**PROJECT# 1010273**

**PROJECT NAME:** NORTH ALBUQUERQUE ACRES Unit(s) 3

DATE: January 23, 2015  
TO: Jack Cloud, DRB Chair  
FROM: Catalina Lehner, Senior Planner   
RE: Project #1010273, La Cueva Assisted Living Facility  
Site Development Plan for Building Permit

B5 EXTERIOR BENCH DETAIL
1/2"=1'-0"

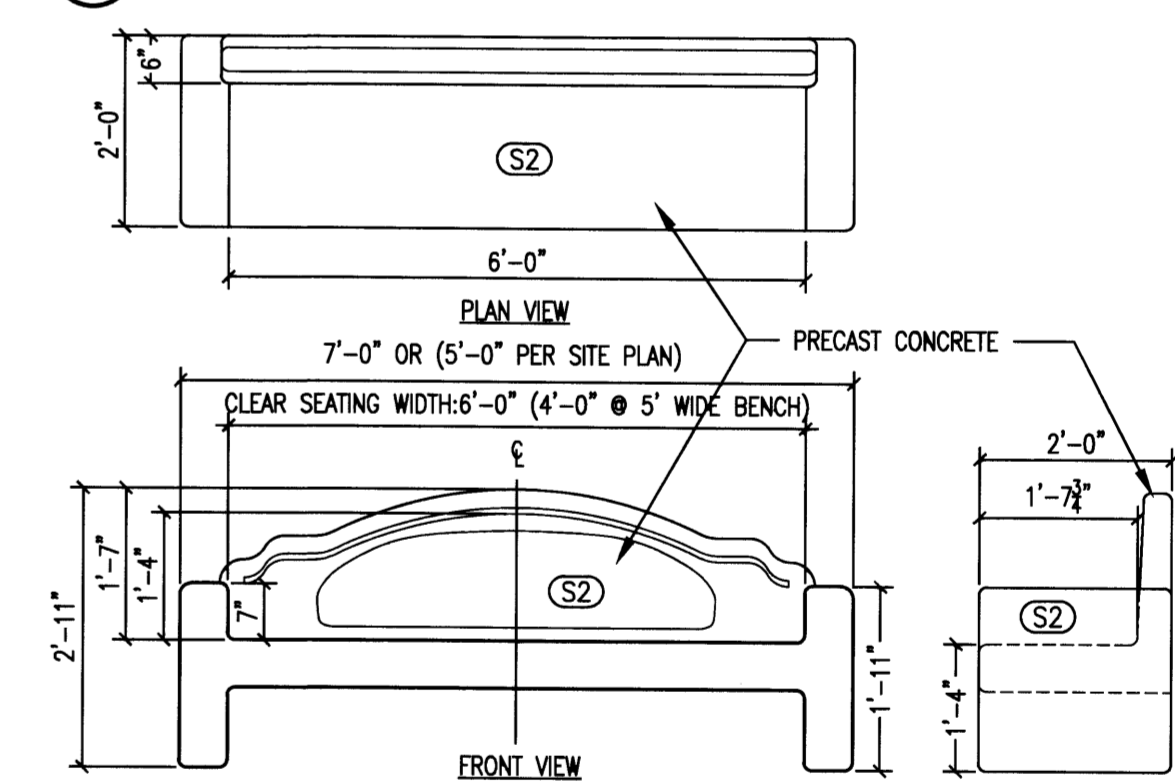
7B- Add a note to the bench detail to explain that some benches have 4 seats and some have 3. Otherwise, it's not clear how the seating calculations were figured out.
